Our Ref: BR/304/11/
Your Ref:

11th January 2012

**Outline Application with all matters reserved for demolition of derelict two storey building & erection of 8 no. 1 bed flats & 6 no. 2 bed flats
18 Durban Road Bognor Regis**

P.01: LOCATION PLAN

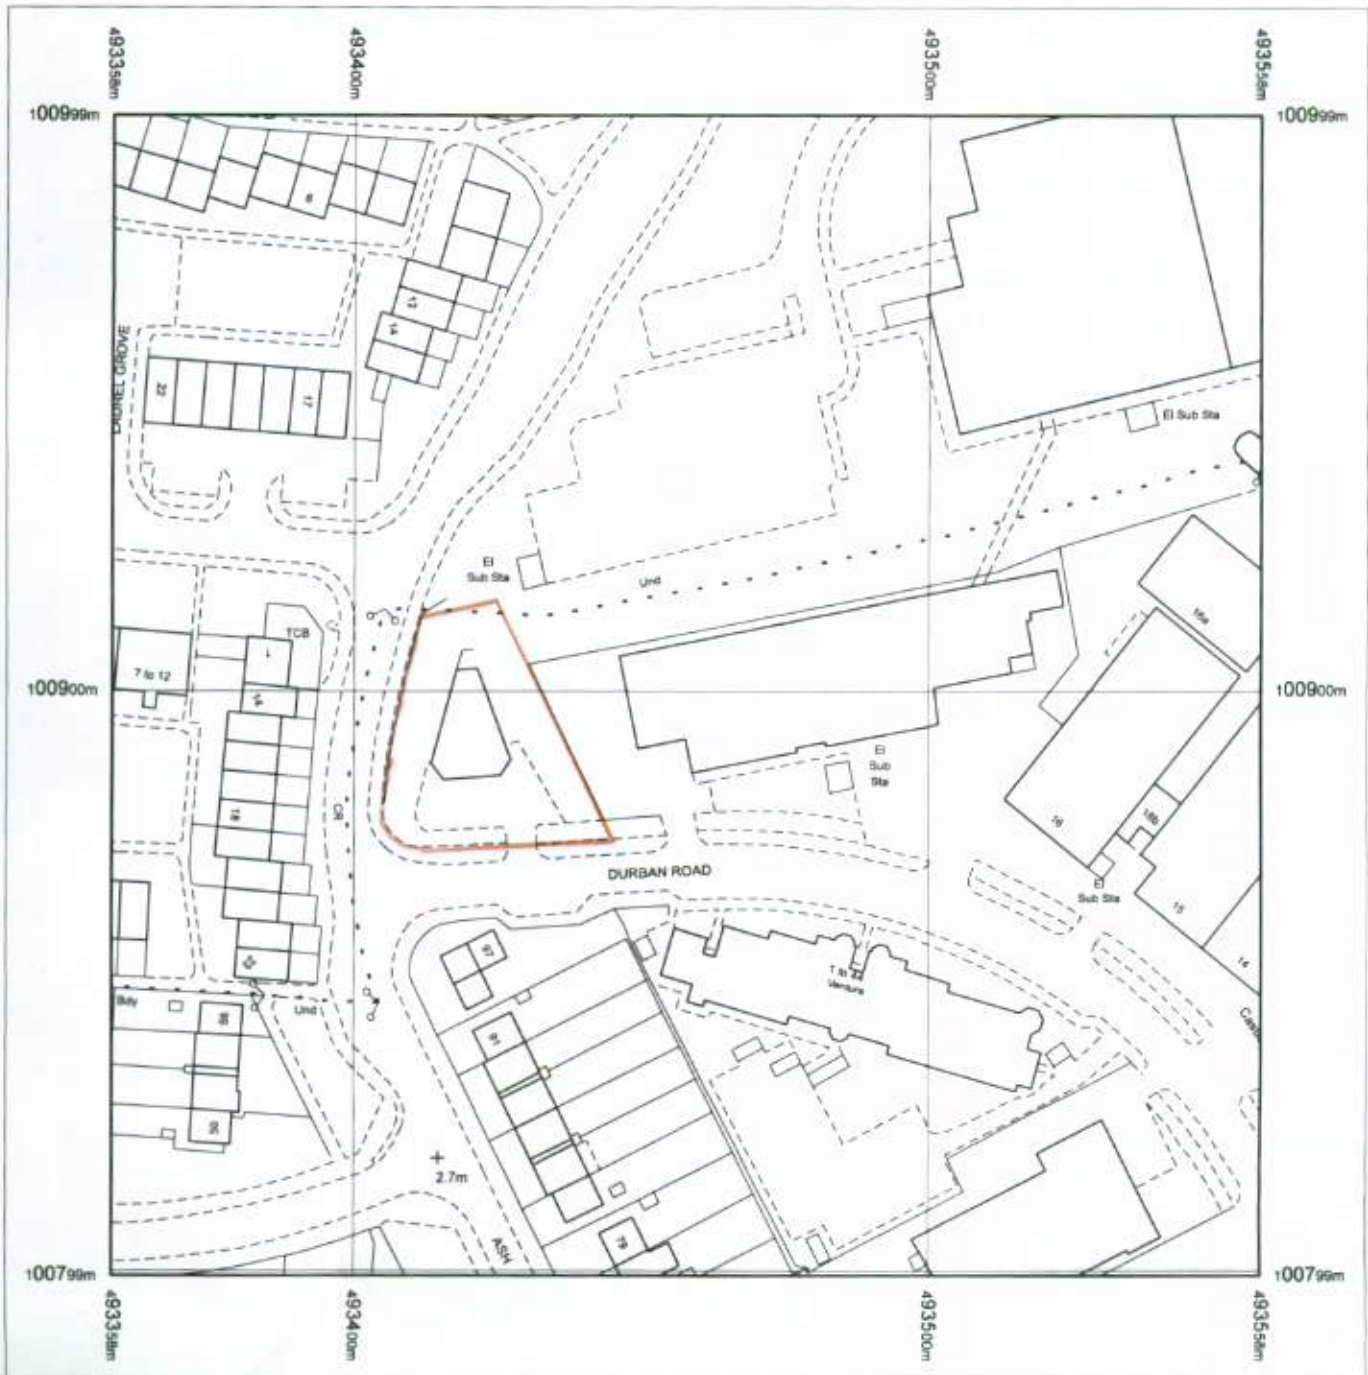
I require 1 electronic or 3 paper copies of a revised location plan at a scale of 1:1250 (the plan provided is not to scale), in accordance with the guidance notes available on our website detailed below (click on National List).
